City of Albuquerque Stormwater Construction Site Inspection Report

ESC File No.	E17/E011B	Project Name:	XRAMM Jefferson Office		
NPDES Id. No.	NMIR1004F1	Location:	5800 Jefferson St NE		
4/26/2023	Owner	Contractor			
Operator	Jefferson 25 XRAY QOZB, LLC	Enterprise Builders			
Contact name & title	Jeff Jesionowski	David Lundsten			
e-mail	jeff@amcdevelopment.net	dlundsten@ebnm.com			
Contact Phone #	259-0991	452-7639			
COA Inspector	Doug Hughes	Start/End Time:	1pm		
Construction Phase:	Lot 1B1 stable but lot 1A1 is dirt				
Type of Inspection:	Regular	Storm Event	Post Storm Event >0.25"	311/Complaint	Follow Up
Weather at time of inspection?	Clear		Temperature: ~	65	
Estimated date of last storm 0.25" or greater	3/16/2023				
Item Number	Deficiency/ Corrective Action				
1	none				
2					
3					
2.1	Discharge off site? (Y/N)	no			
4	Self Inspection Reports	n/a	Latest report Date:	3/28/2023

EROSION AND SEDIMENT CONTROL PLAN

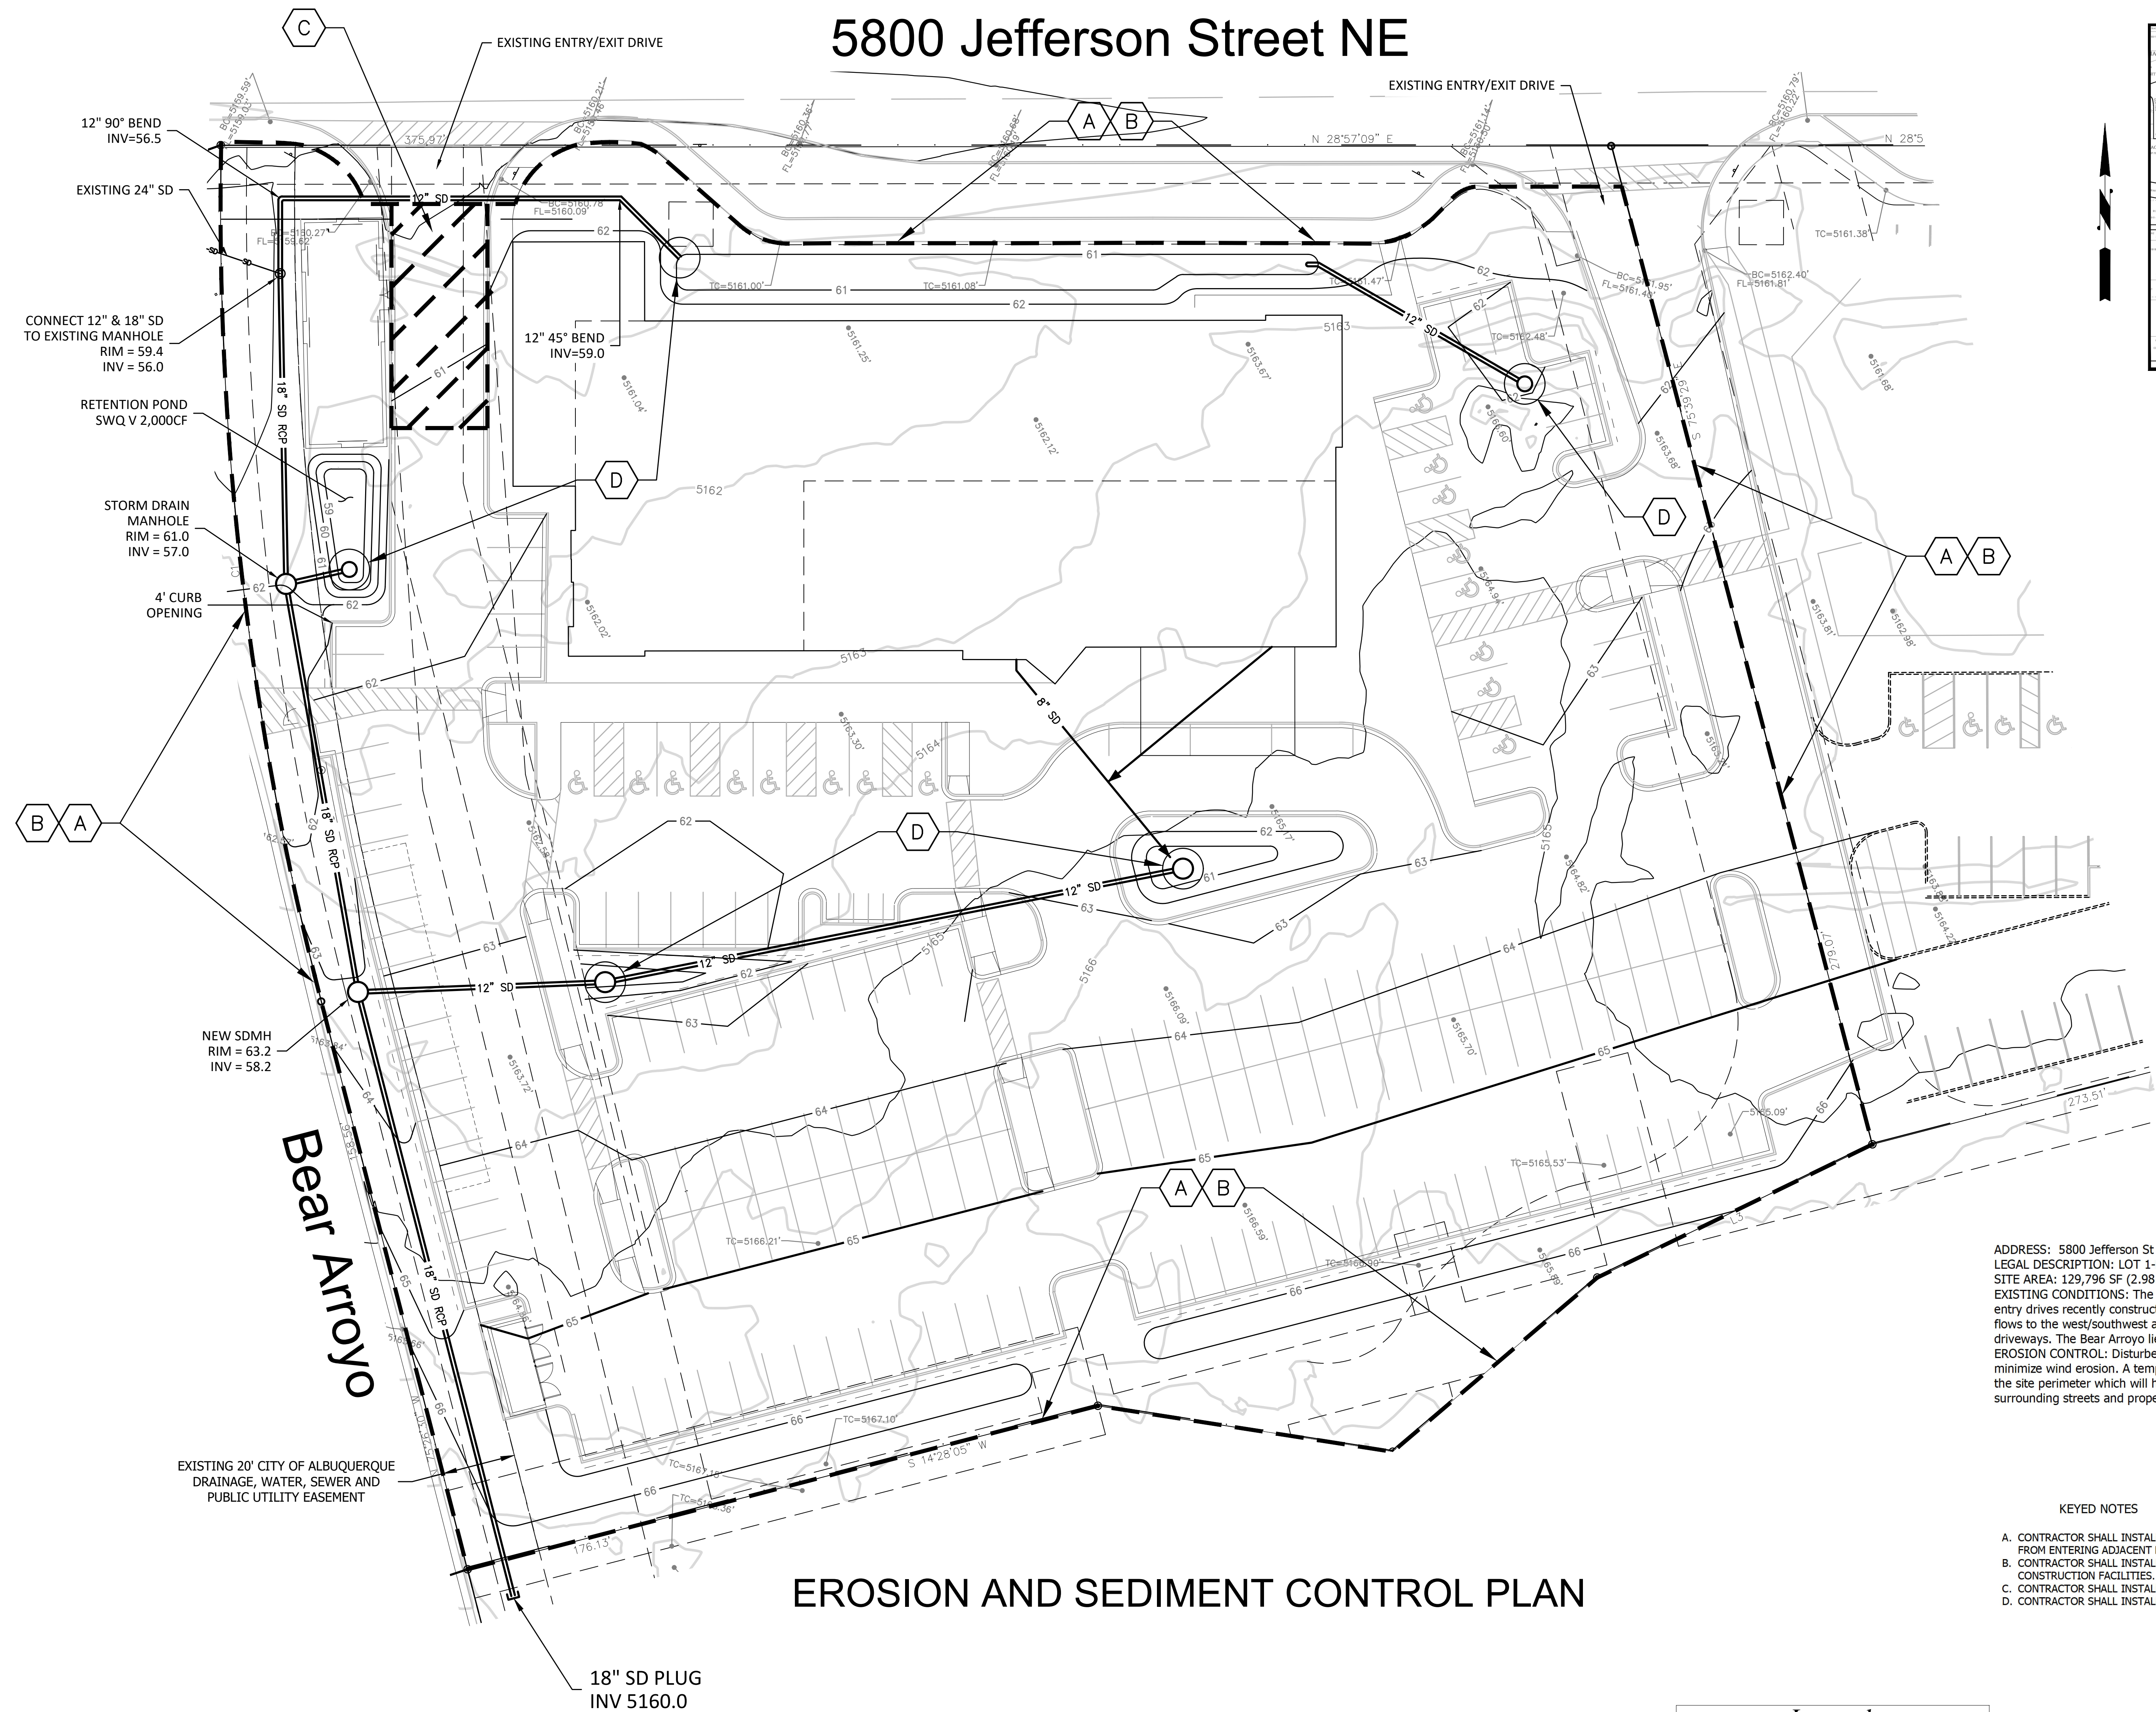
Notes:	Stabilization missing north of entrance and trailer gone so SWPPP not checked
